Your Ref :
Our Ref : EP/119/17/NMA

**Section 96A of the Town & Country Planning Act 1990 (as amended)
Town and Country Planning (Development Management Procedure) (England) Order 2015 (as amended) - Article 10**

**Application for a non- material amendment following the grant of EP/6/17/HH to reduce the height of the outbuildings & change roof tiles from Grey roof tiles to Redland Concrete Plain tiles Charcoal Grey.
Sandcastles, 32 Tamarisk Way, East Preston,**

Drawing Number: 1069.03 e

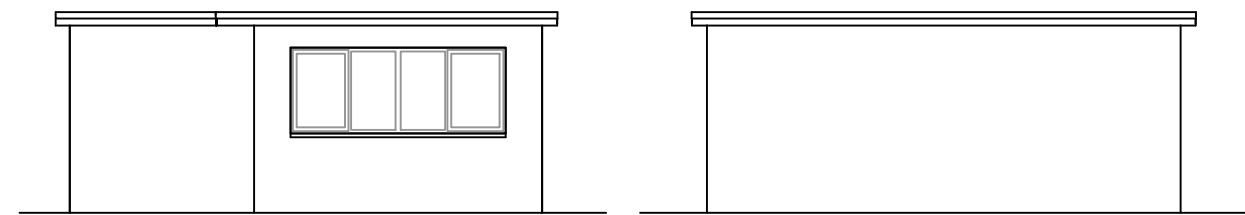
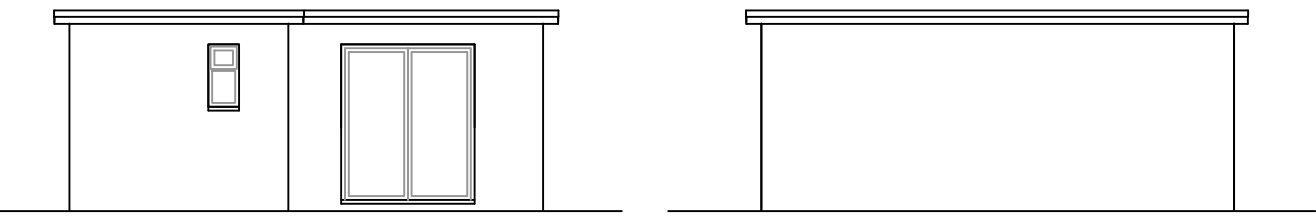
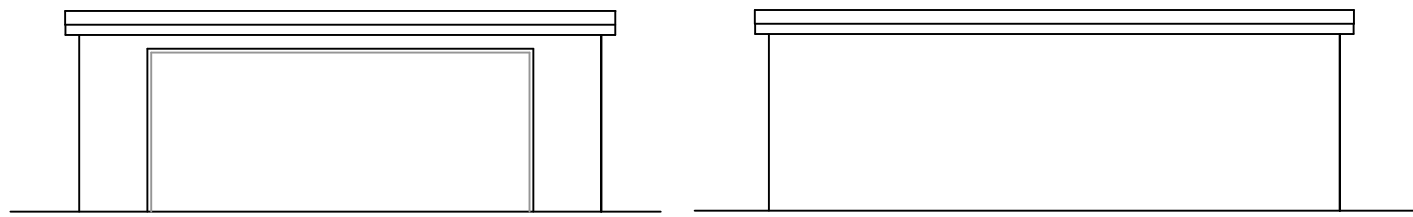
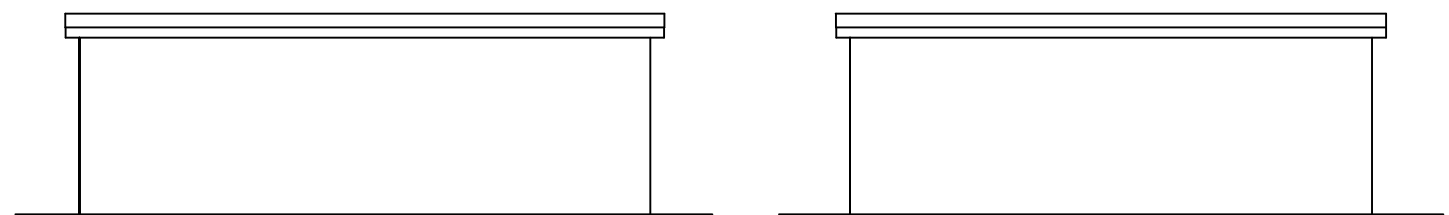
I refer to your recent application for a Non Material Minor Amendment. You propose reduce the height of the previously approved outbuildings through the removal of the previously proposed hipped roofs and use of flat roofs.

I have assessed these changes having regard to our guidance on non-material amendments and having regard to the local resident objections raised to application EP/6/17/HH. I find the changes to be acceptable as a Non-Material Minor Amendment. Please note that the plan listed below now become part of the approved plans for EP/6/17/HH;

· Proposed Site Plan, Proposed Works to Existing Garage and Proposed Garage - 1069.03.e
